From: Martyn White
Sent: 29 August 2019 17:20
To: Amber Willard <Amber.Willard@arun.gov.uk>
Subject: AW/212/19/HH

AW/212/19/HH

The application seeks to make comprehensive alterations to the building, including the replacement of an existing extension and conservatory with a single storey rear extension, balcony area and a loft conversion. It also proposes replacement windows, doors, whilst also cladding and re-roofing to house. The existing boat house would be painted white.

North-West (Front) Elevation - Proposed

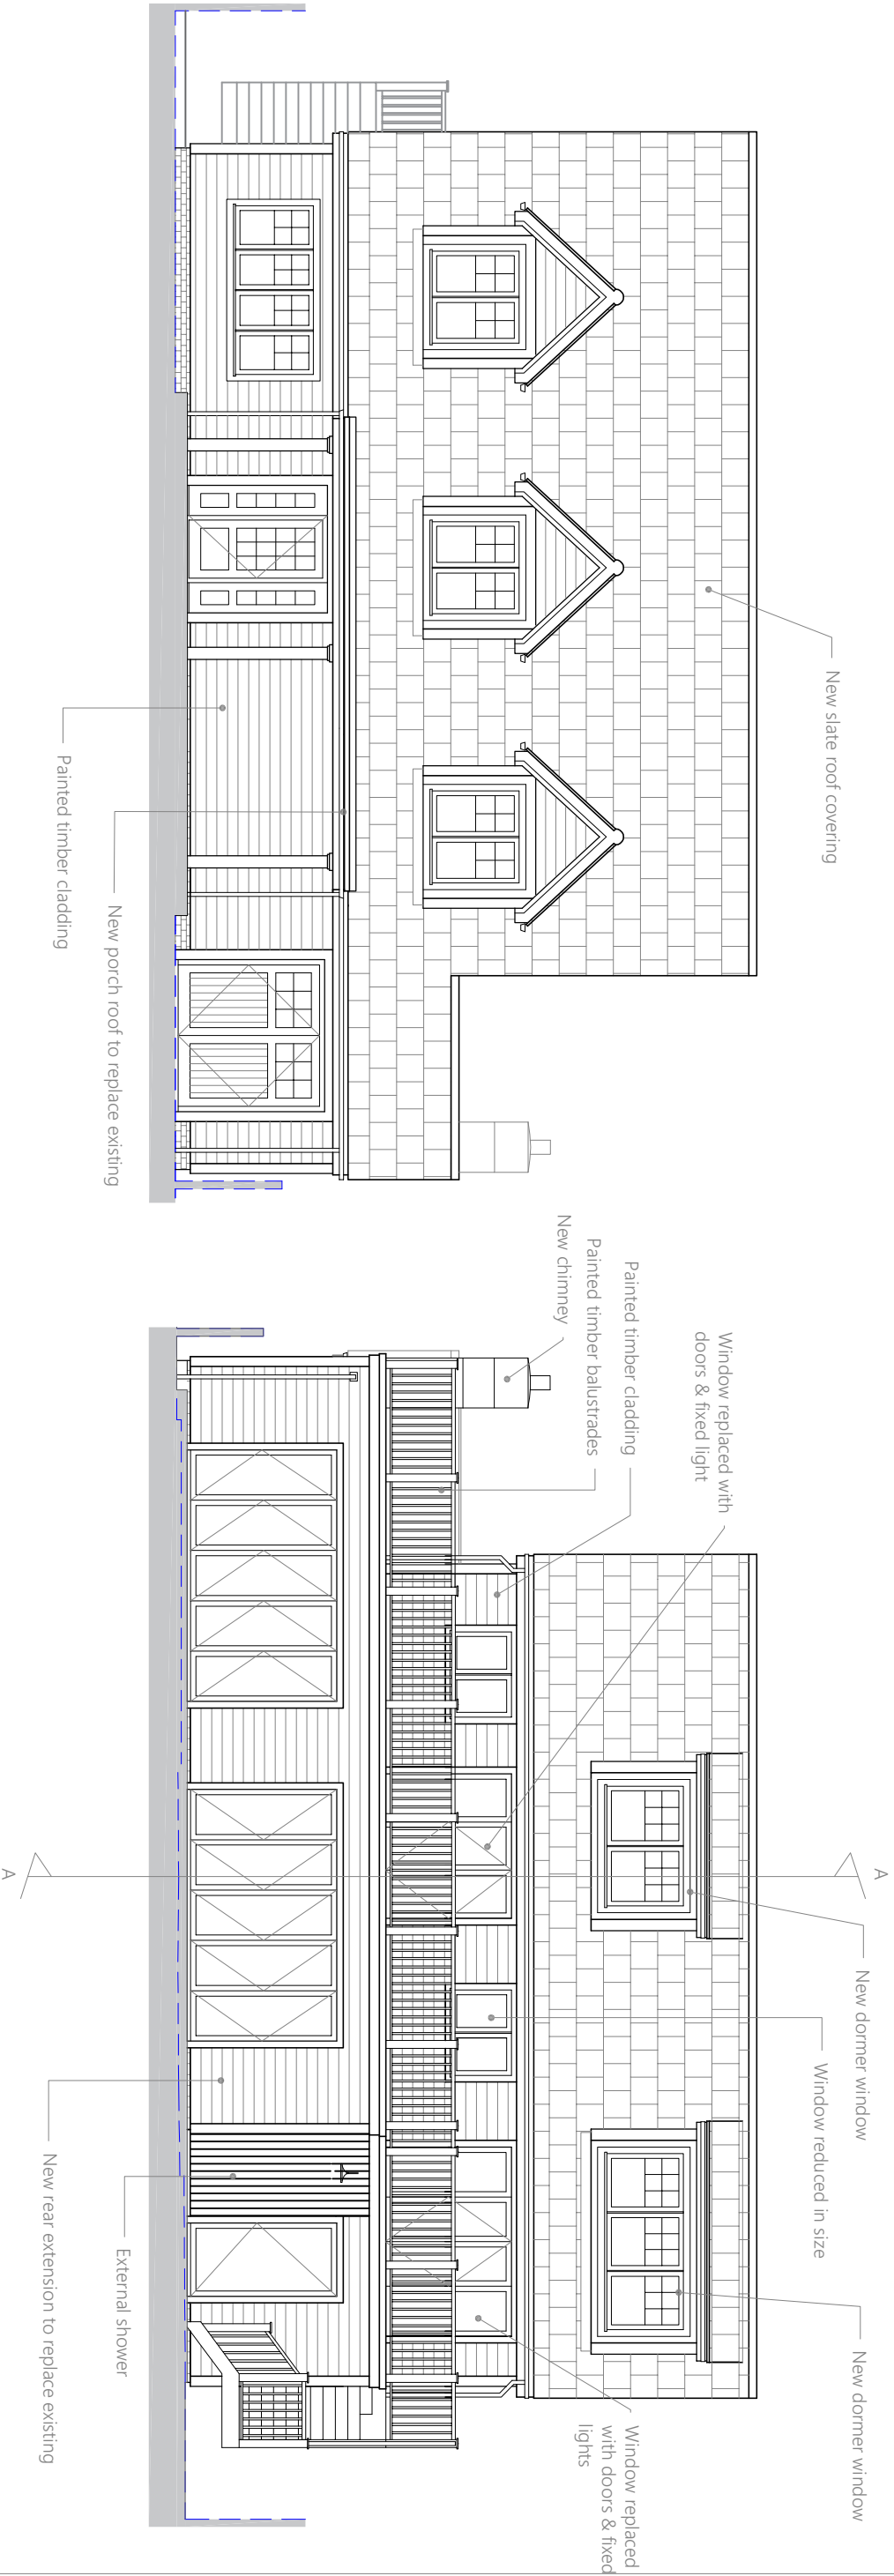
However, the principal concern relates to the alterations to the materials to be used for the external appearance of the building. As previously mentioned, the estate attempts to reflect a more traditional aesthetic where a Tudor appearance was preferred.

The use of painted cladding on all of the elevations and slate on the roof provides the building with a more 'New England' appearance, which is not normally associated with the conservation area. It is therefore considered to conflict with the established character of the estate.
